Rustington Parish Council

Date: 3 December 2021

R/108/21/PL - Demolition of two dwellings and the construction of 3 No. 3-bed town houses and 5 flats. This site is in CIL Zone 4 and is CIL Liable as new dwellings - 117 Sea Lane, Rustington

DRAWING TITLE 3D Views

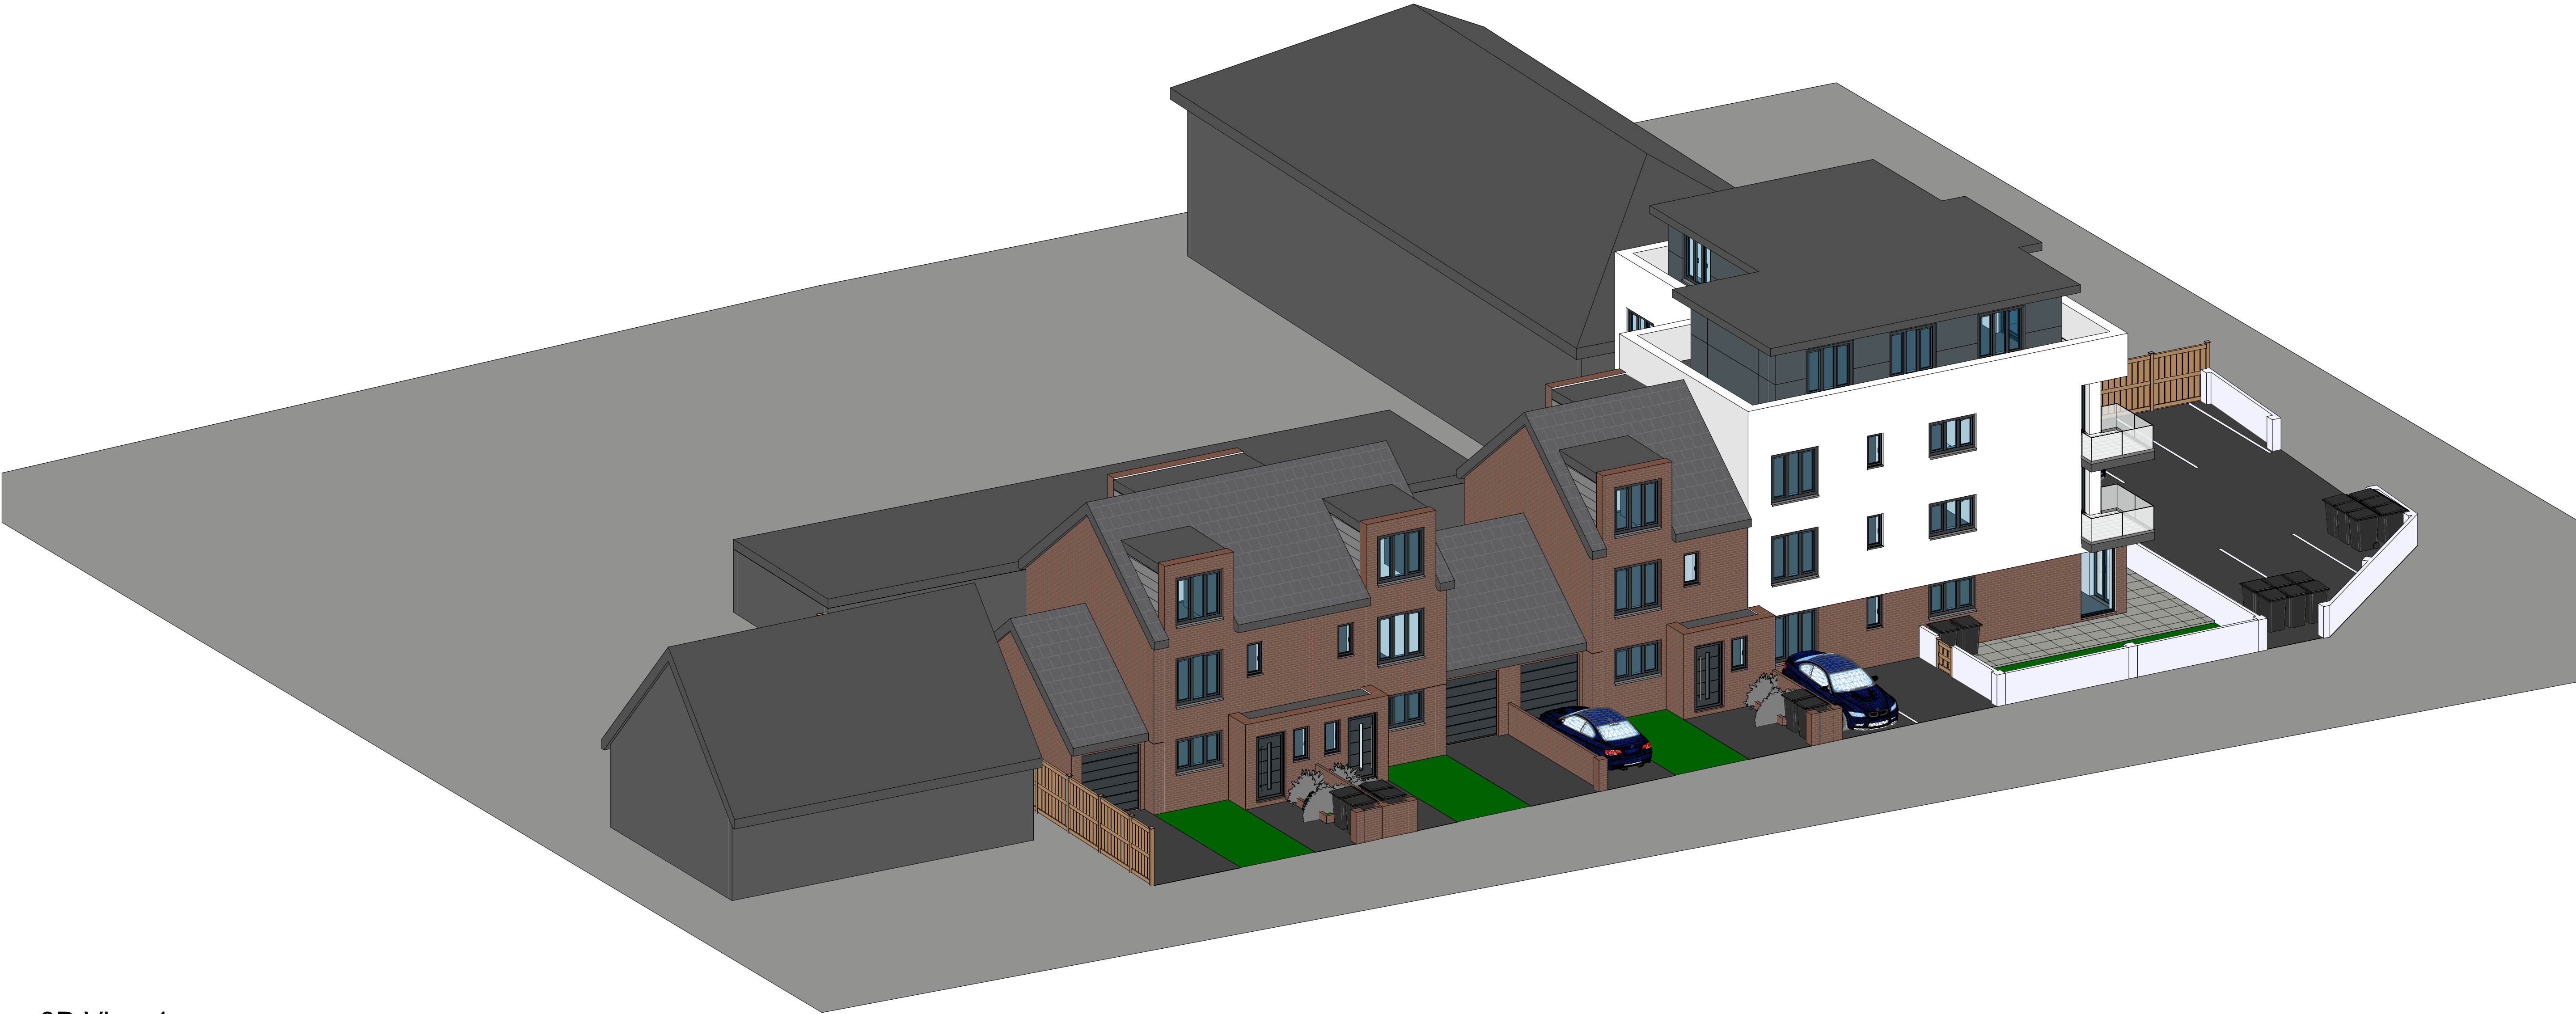
- (i) The proposal to develop this site by the erection of 3 No. 3-bed town houses and 5 flats would still present an extreme over-dominant appearance and would have a damaging impact, by reason of their shape and mass, on the residential amenities of properties in close proximity and the appearance of the street scene (In conflict with Arun District Local Plan Policy DSP1)

- (x) The proposal is in conflict with the Rustington Neighbourhood Plan (Policy 2: Housing Design) on many counts, including scale, density, massing, height, landscape design, layout and materials

A REV	27/10/21 DATE	Second floor removed. DESCRIPTION	18th Mar 2021		EL	
			DRAWING TITLE PROPOSED STREET ELEVATIONS 1			
			SCALE 1 : 100@ A1		DRAWING NO. P202

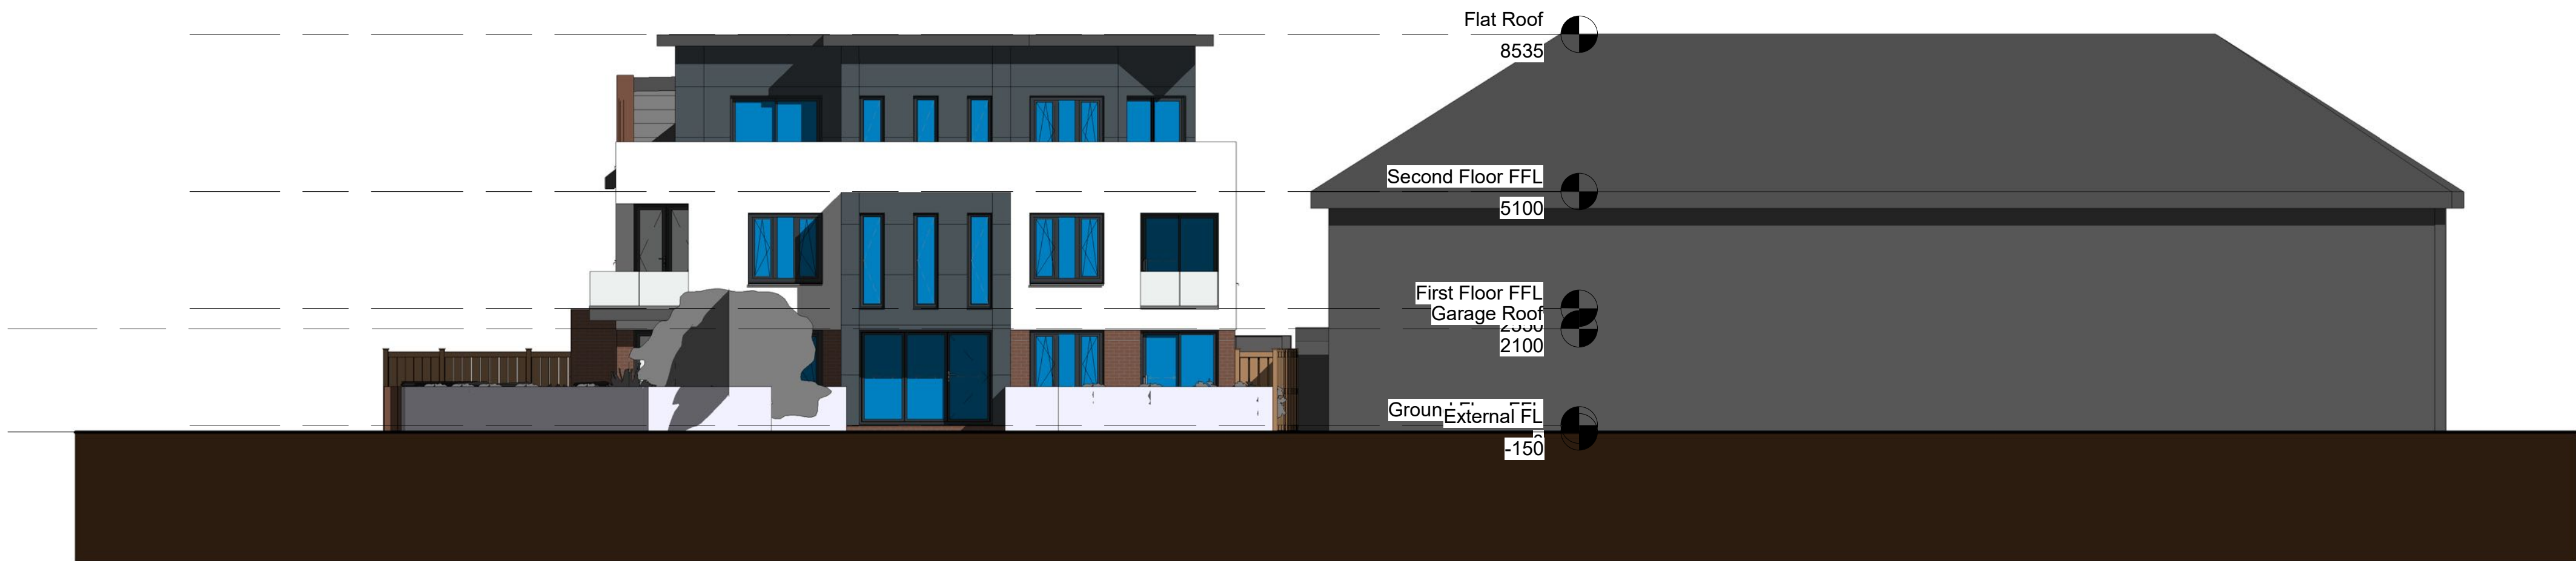
- (ii) The proposal, which would be taller than No. 2 Shaftesbury Road, would present an over-bearing and unsympathetic appearance for the occupiers of this property, in particular, which would result in a loss of privacy by reason of overlooking and would, most certainly, adversely affect the quiet enjoyment of the occupiers of the aforementioned property

- (xi) The design of the flats with a flat roof is totally out of keeping architecturally with all of the other properties in the immediate area which have pitched roofs
